Your Ref: OWPC23897
Our Ref: EP/74/19/HH 18-06-2019
Please ask for:
Zac Denton

Hip to barn hip extension, north dormer extension, single storey rear extension.
2 Hillview Crescent East Preston

I am commenting on this application on behalf of the East Preston and Kingston Preservation Society.

Proposed Elevations

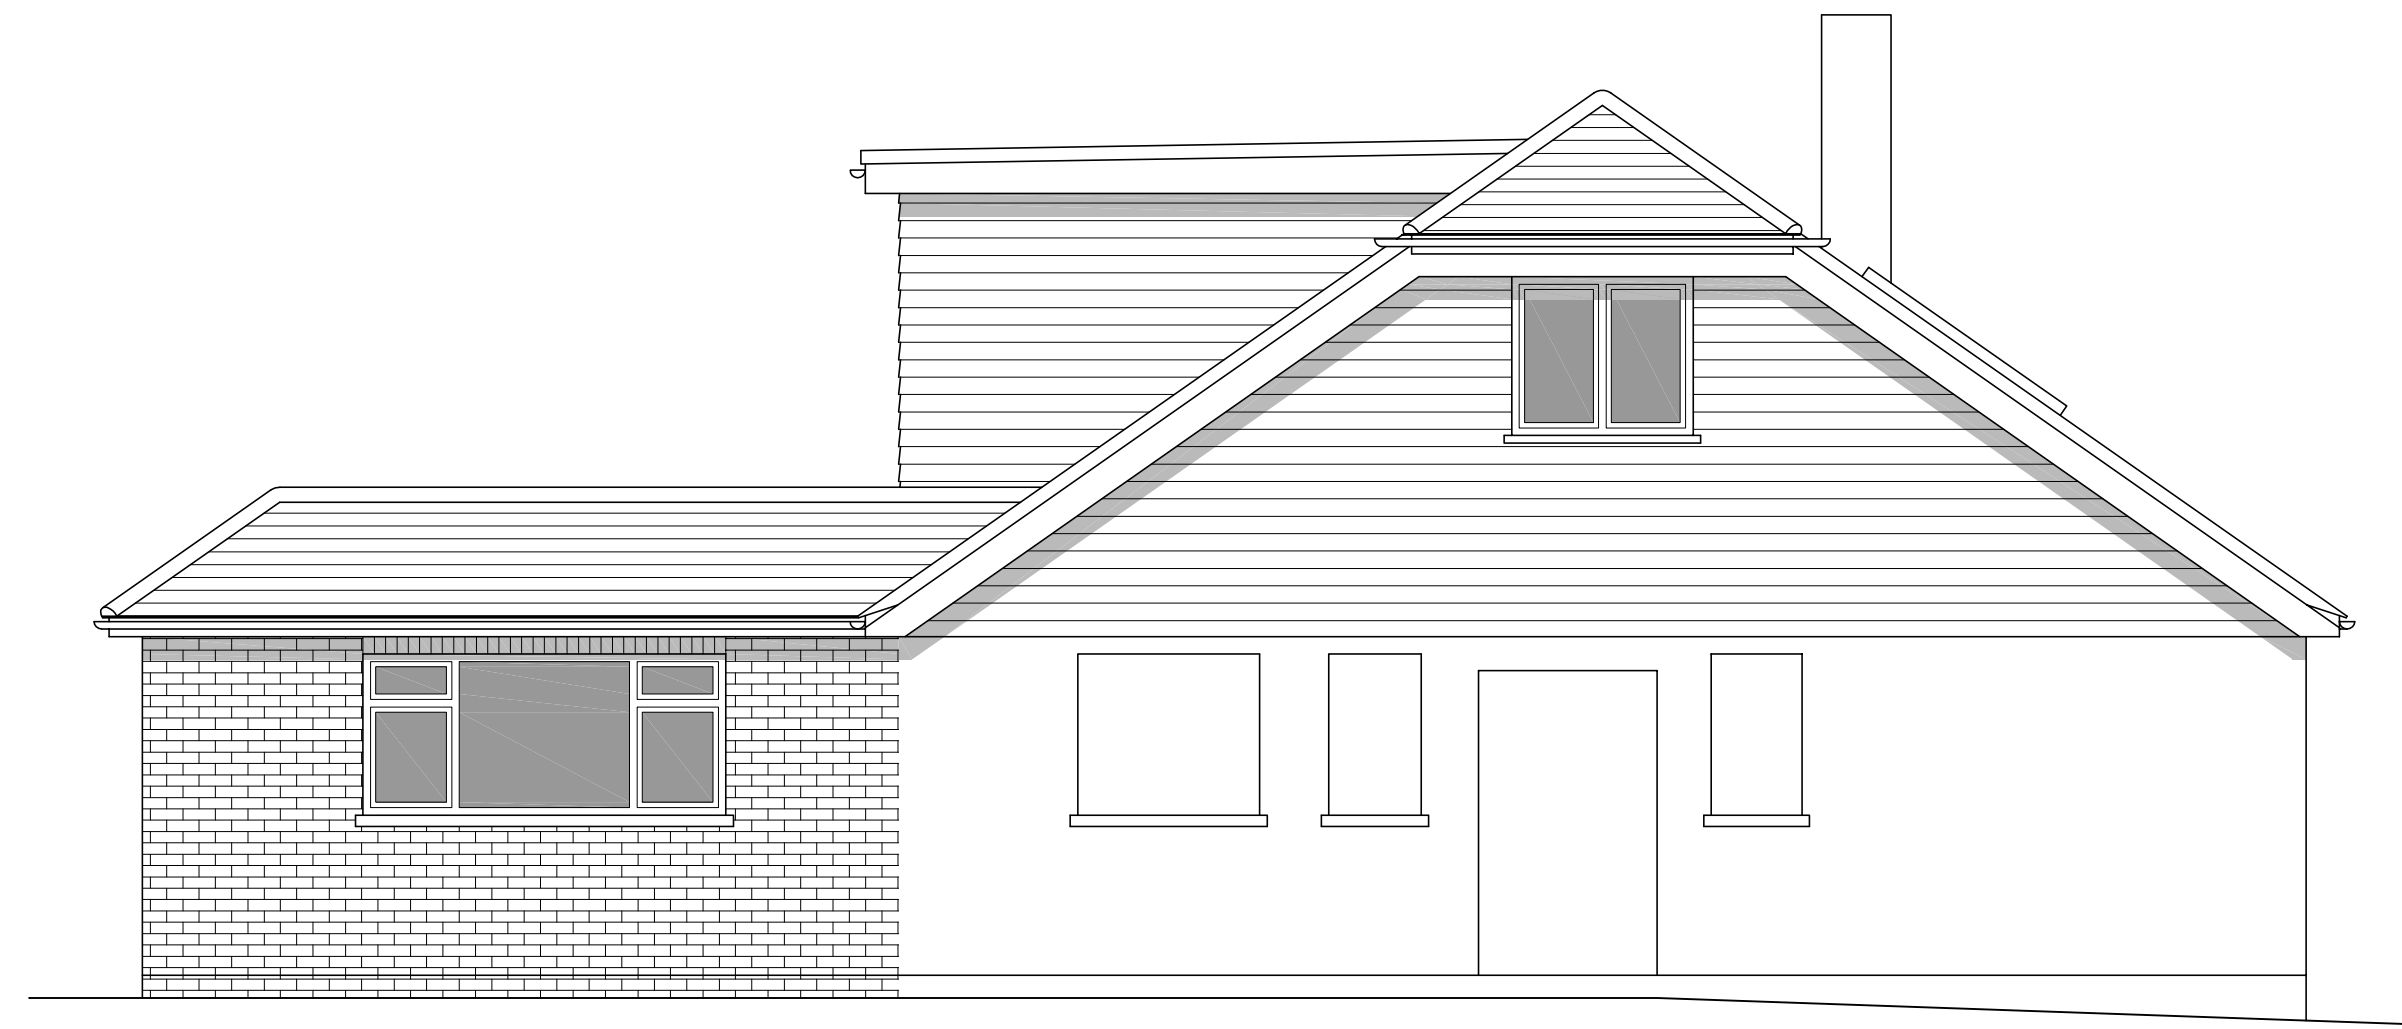
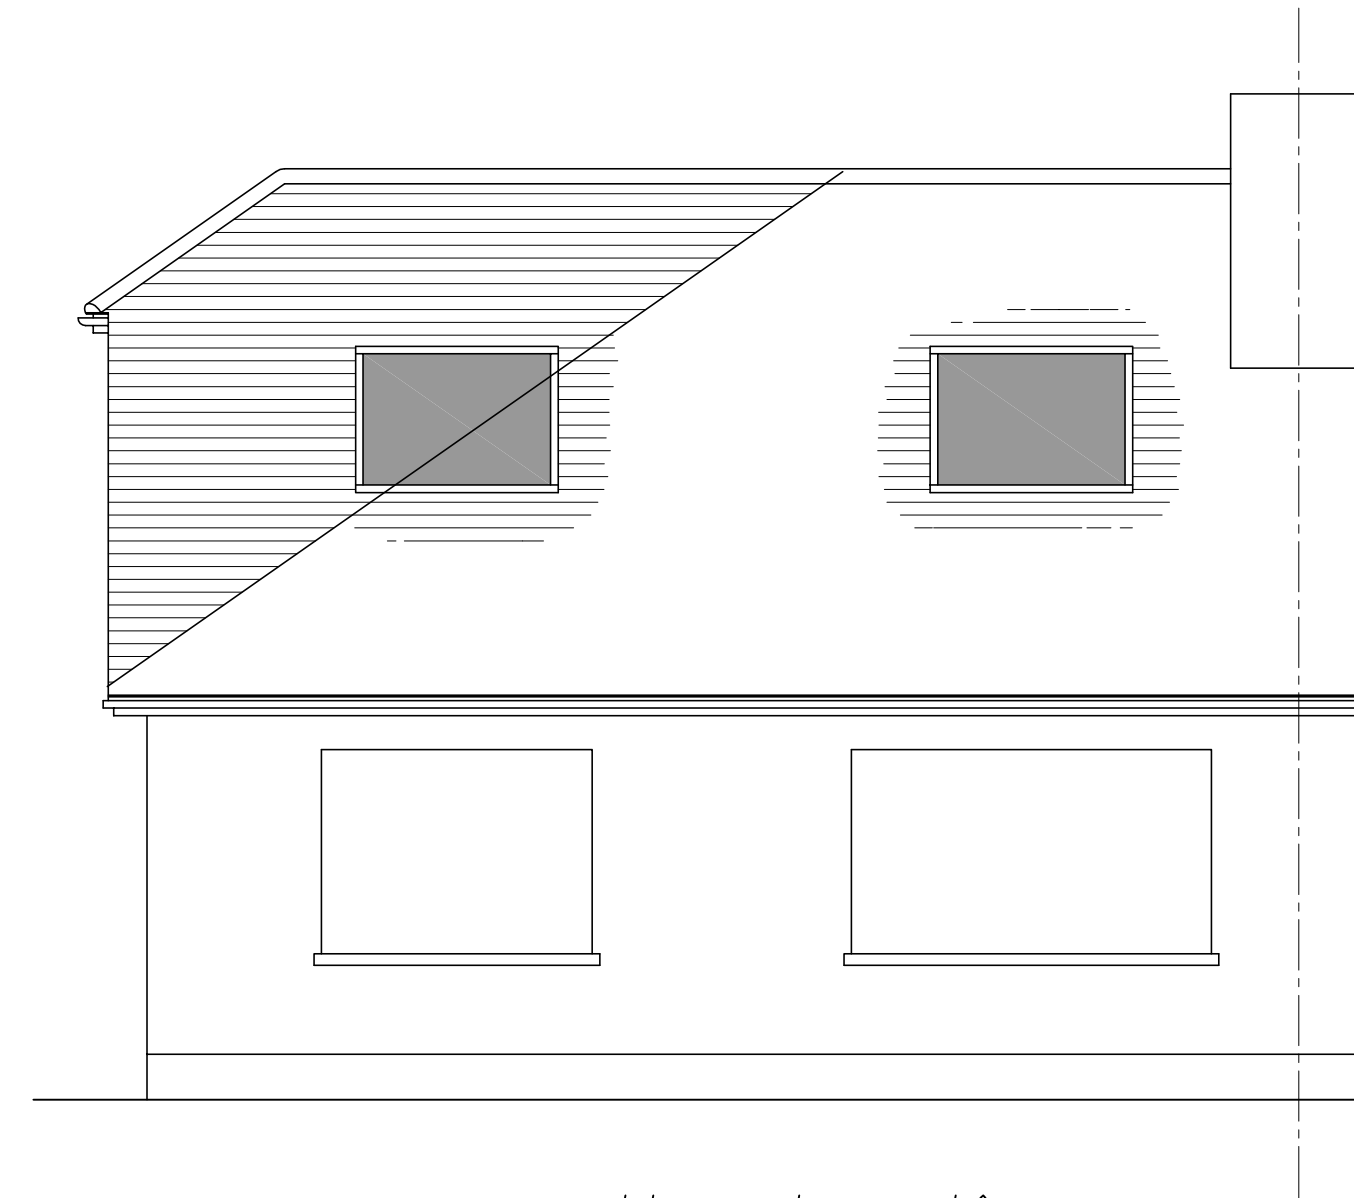
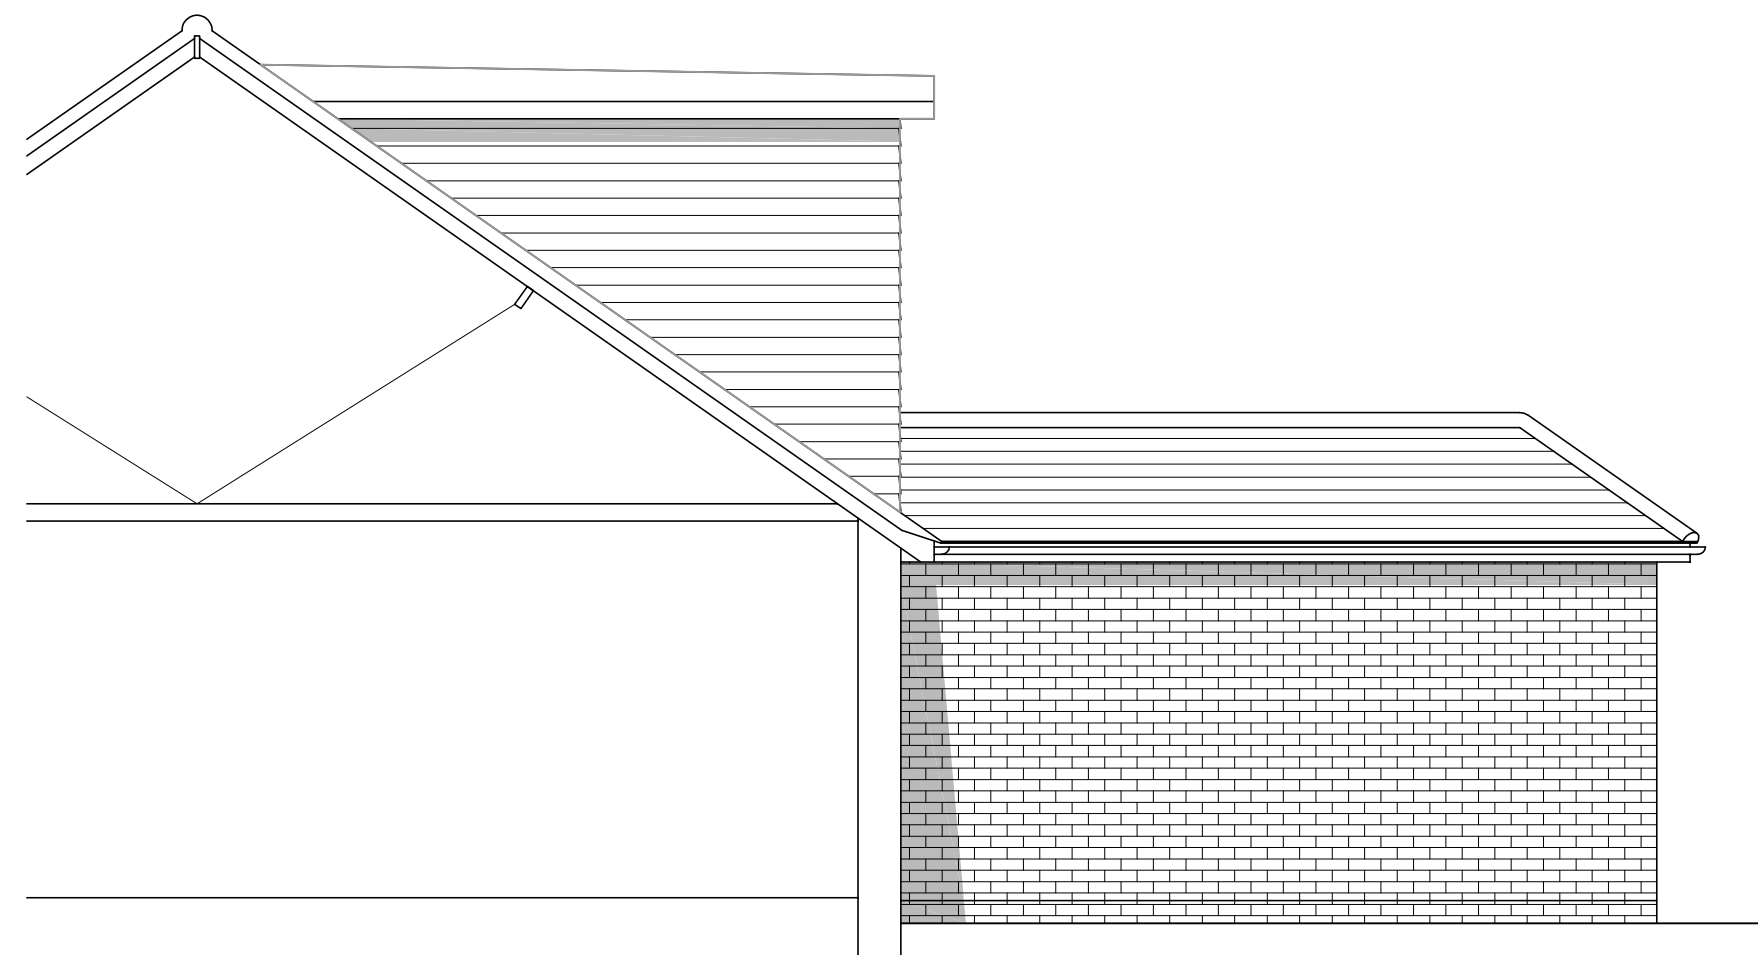
The previous application, for very similar alterations to this property, was refused because they would have an unacceptable discordant and incongruous impact on the character and appearance of the host dwelling and the locality; and because the rear dormer would create an unacceptable loss of privacy for dwellings to the north.

The present application differs from the refused application only in having a slightly smaller rear dormer. This small reduction in its size does not reduce the impact it would have on the appearance of the host dwelling or of the locality; and it would not reduce its overlooking effect on properties to the north.

This application therefore remains contrary to policies D DM 1 and DM4 of the Arun Local Plan, and policies 1 and 3 of the East Preston Neighbourhood Plan.
